From: Sarah Burrow <Sarah.Burrow@arun.gov.uk>
Sent: 11 November 2019 11:57
To: Planning.Responses <Planning.Responses@arun.gov.uk>
Cc: Anita Gardner <Anita.Gardner@arun.gov.uk>
Subject: RE: Planning Consultation on A/161/19/DOC

Engineers Comments Regarding Surface Water Drainage Design

APPLICATION NO: A/161/19/DOC

Site Address: Pound Place Roundstone Lane Angmering BN16 4AL

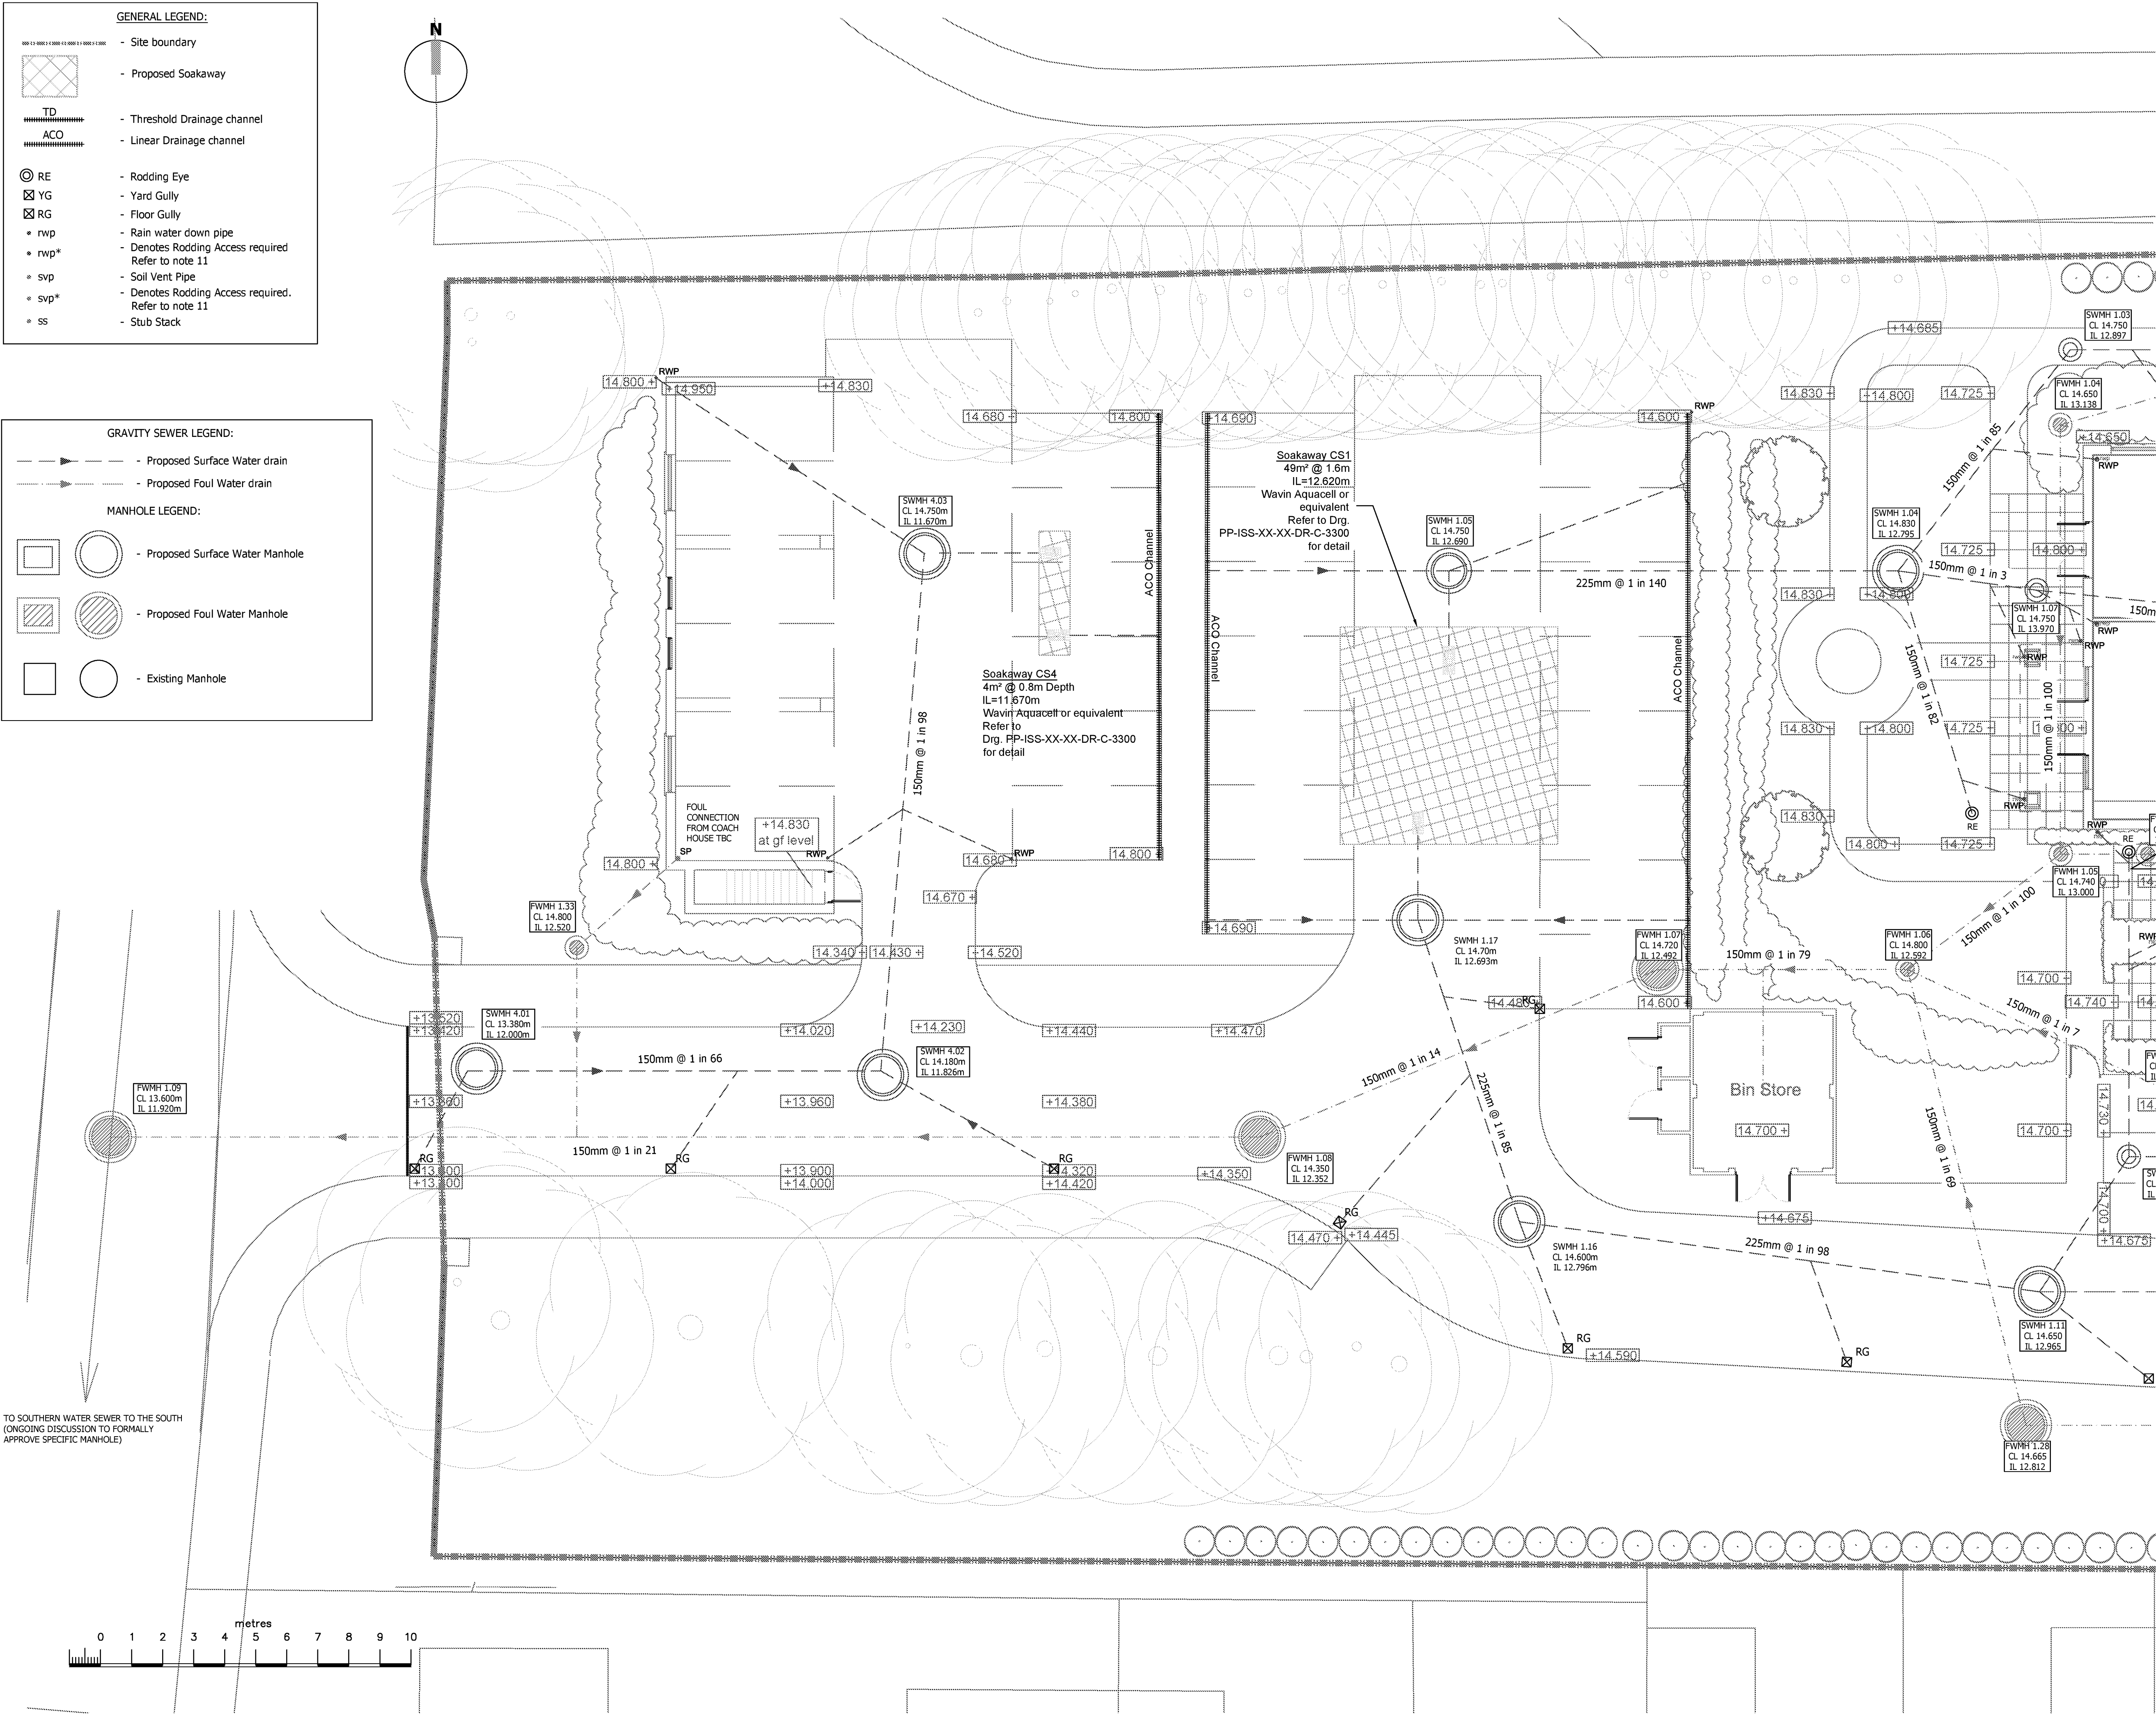
1. The proposed drainage plan in the Drainage Design Calculations differs significantly from the Drainage Layouts supplied. The number and locations of soakaways are different. Please clarify which plan is to be used and remove the other. If the calculations need to be amended for the Drainage Layout drawings please do so.

3. It is unclear as to whether or not permeable paving is to be used. In the Drainage Design Calculations permeable paving is referenced multiple times but this does not seem to be shown on the Drainage Layout drawings, or on the construction details. If permeable paving is to be used please clearly mark it on the layout drawings and include construction details for it. If not please amend the Calculations and provide justification for the change in strategy.
